From: Edward Ledwidge [REDACTED]
Sent: 07 July 2015 15:46
To: Neil Crowther
Subject: RE: A/23/15/OUT - Revised Site Plan - RE: Land South of New Road A259 and East of Brook Lane

In response to comments raised by WSCC in respect of highways matters please find attached a revised site plan 1217-P-11 Rev D.

| Drawing Number<br>1117-P-11 | Revision<br>E    |

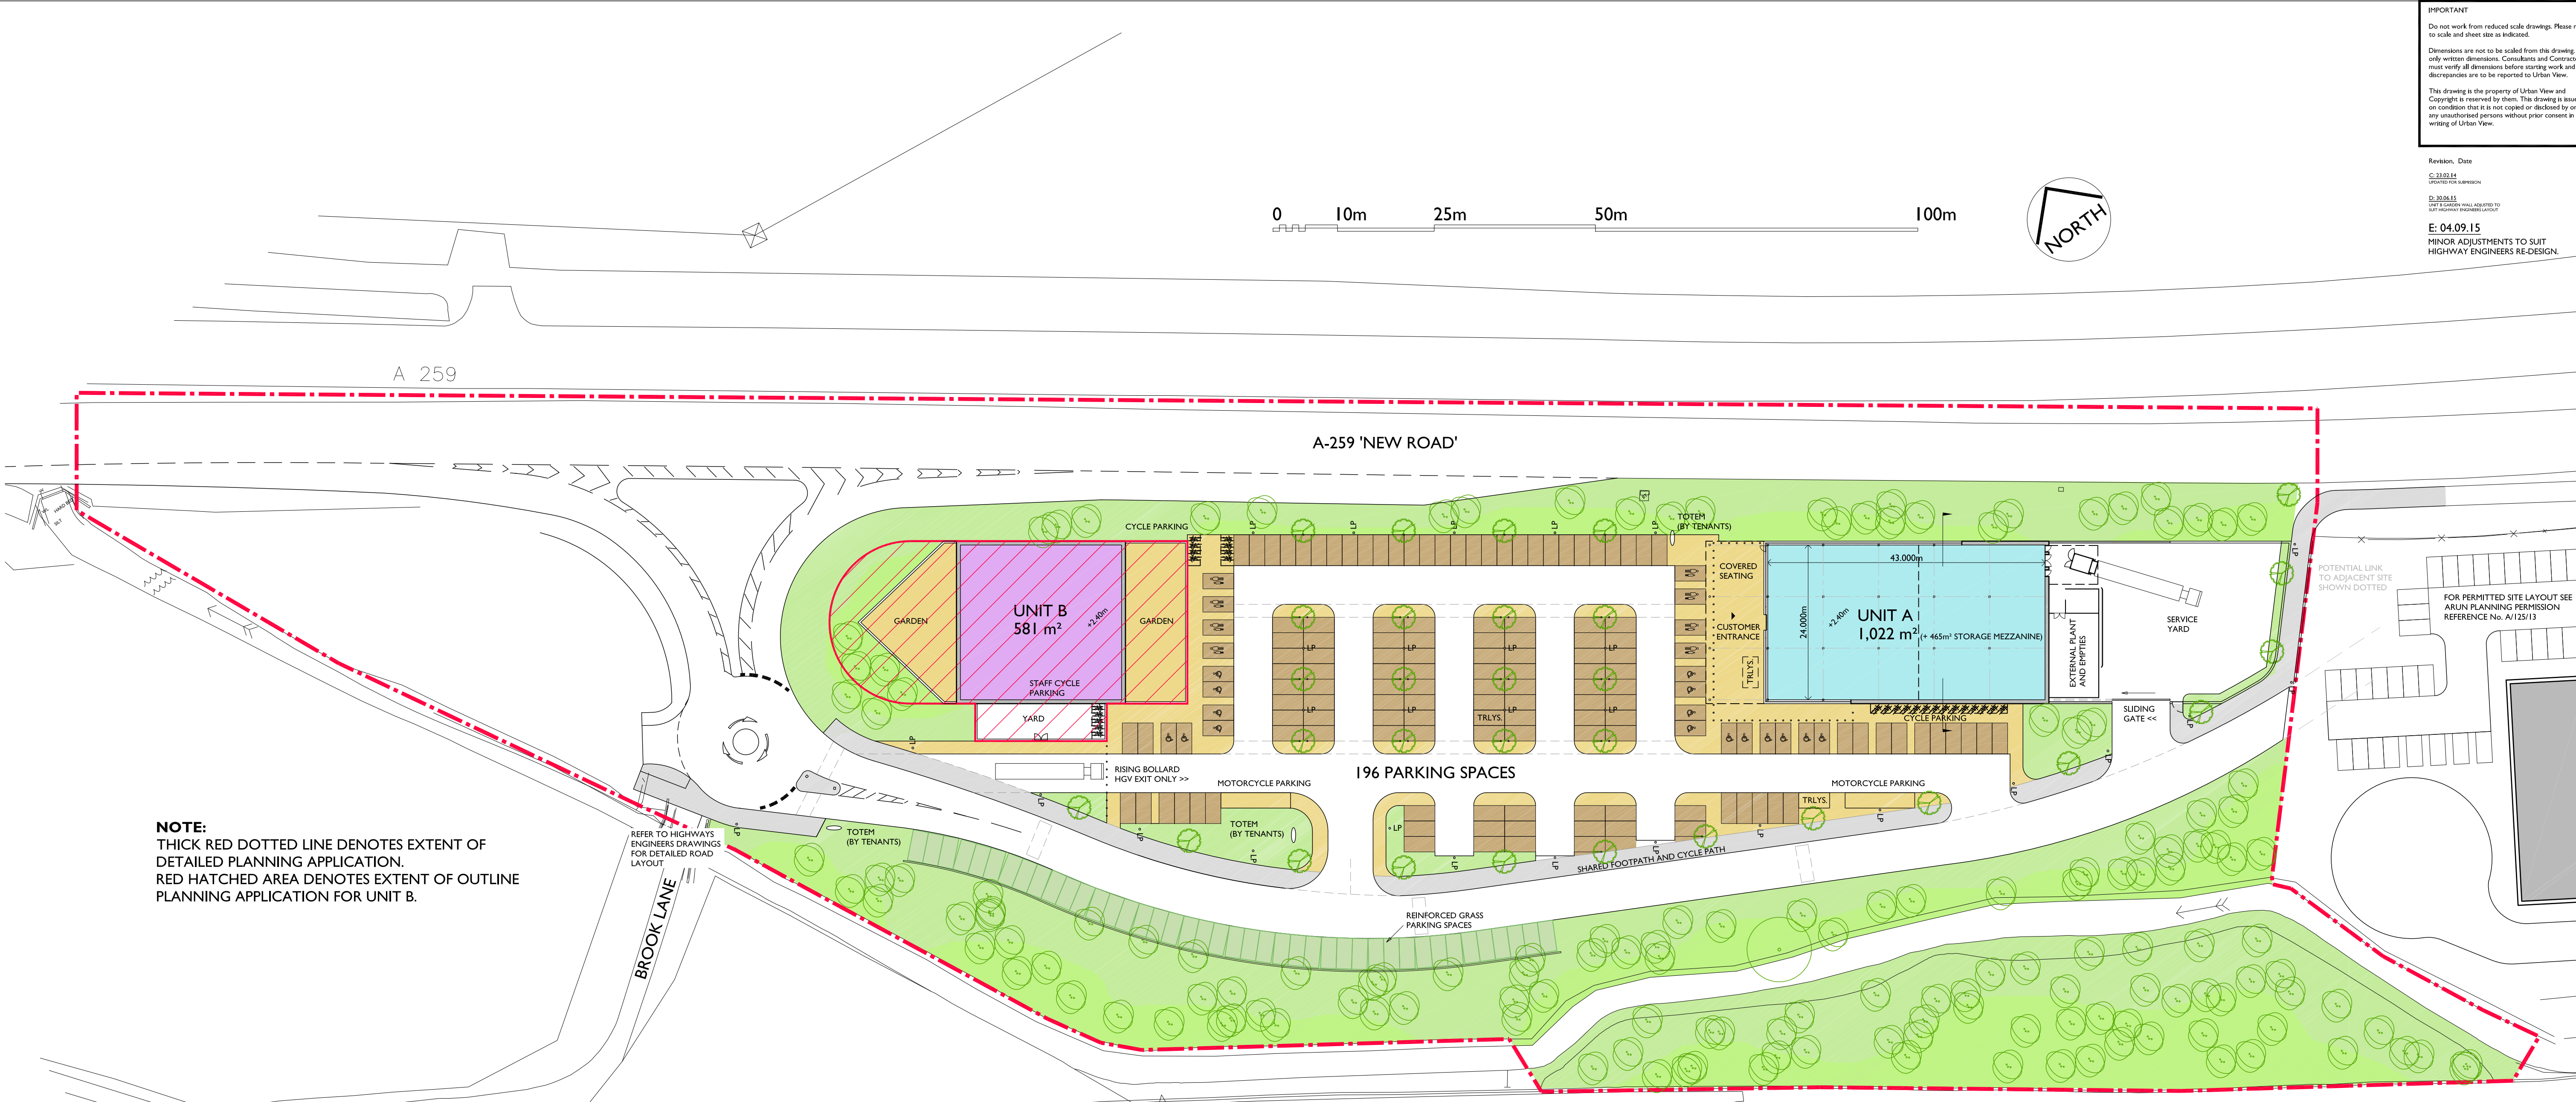
The garden to the proposed public house has been adjusted to accommodate an improved forward visibility splay.

The cycle parking has been increase to 30 spaces (20 serving M&S and 10 serving the public house).
